Ms Tahlia Alexander
A/Team Leader, School Infrastructure Assessments
Locked Bag 5022
Parramatta NSW 2124

10 May 2022

New High School in Jerrabomberra (SSD-24461956)
Response to request for additional information

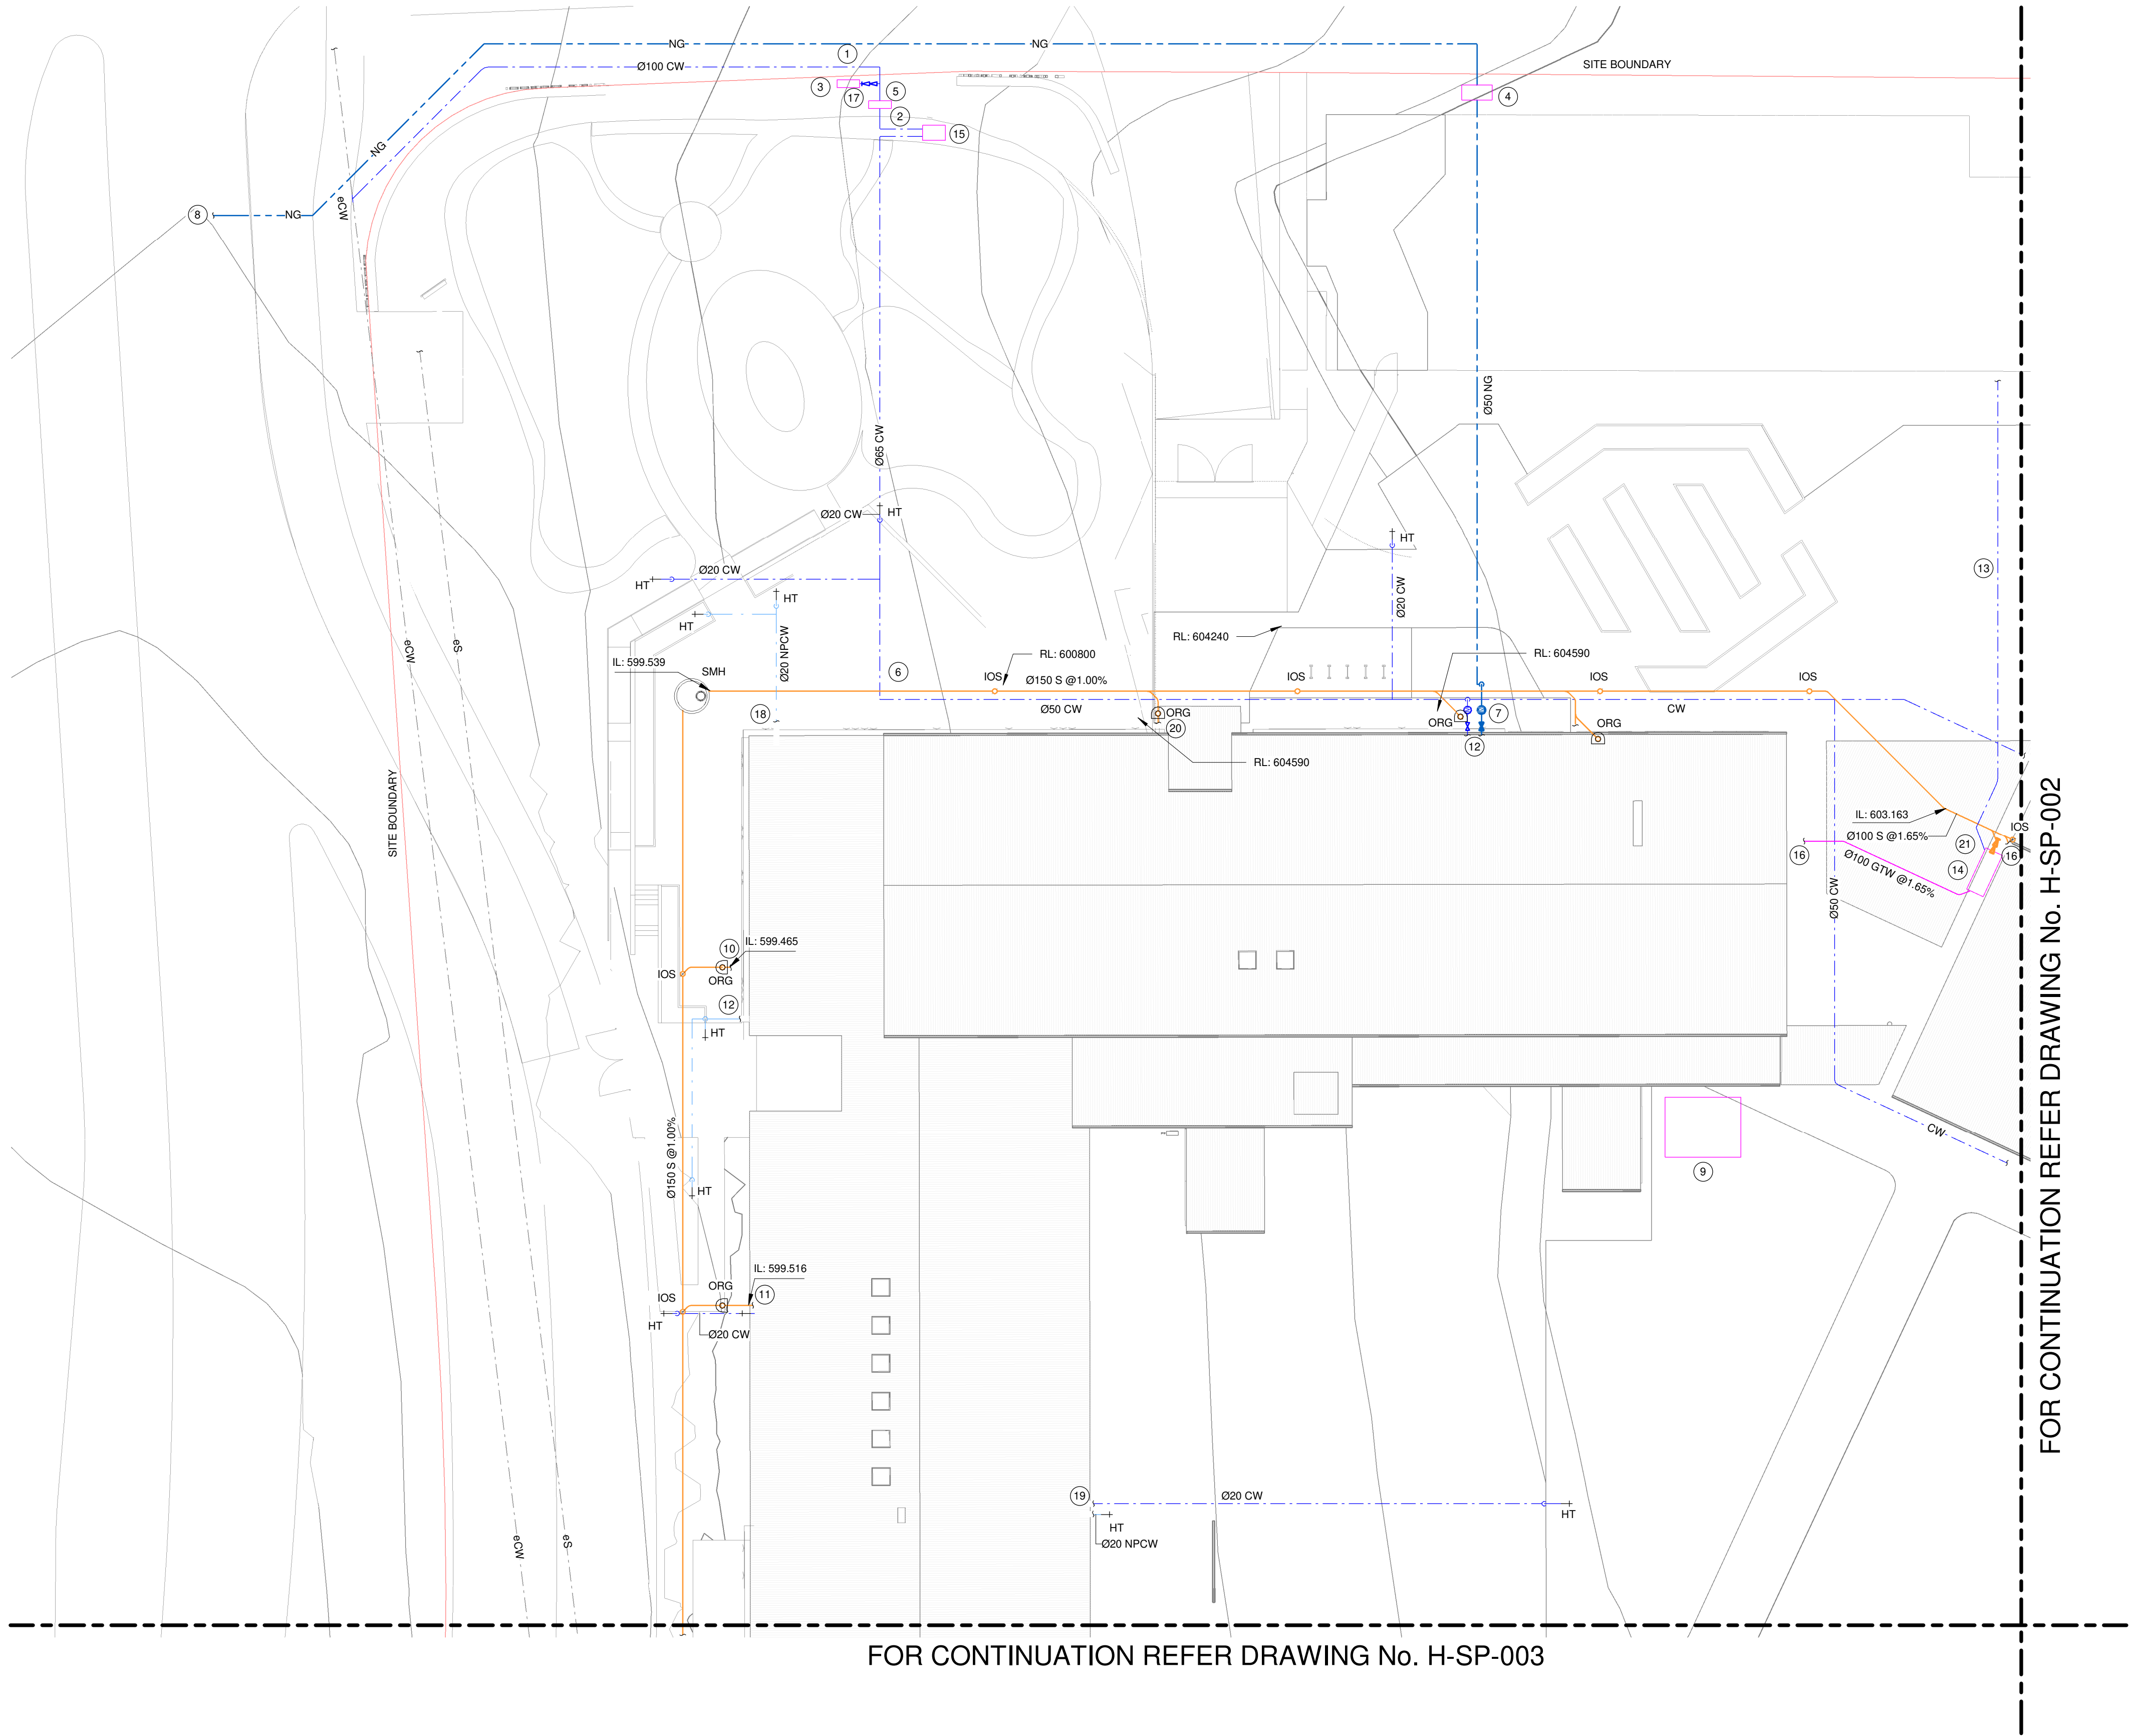
Address Section 2 of Council's comments regarding potable water supply and sewer servicing.

For this item Council states that "The proponent has made no reference to hydraulic design for potable water supply and sewer servicing" and has recommended "That the consent authority impose conditions requiring the preparation of a hydraulic design plan providing details of the required sizing for all water, sewer and stormwater services required for the site".

A hydraulic services site plan has already been provided—see NDY's response at Appendix 9 of the Submissions Report. The plan shows the location and sizing for the water and sewer services for the site. The new cold water and sanitary drainage provisions to the school connect to the authority mains contained within northern stub road.
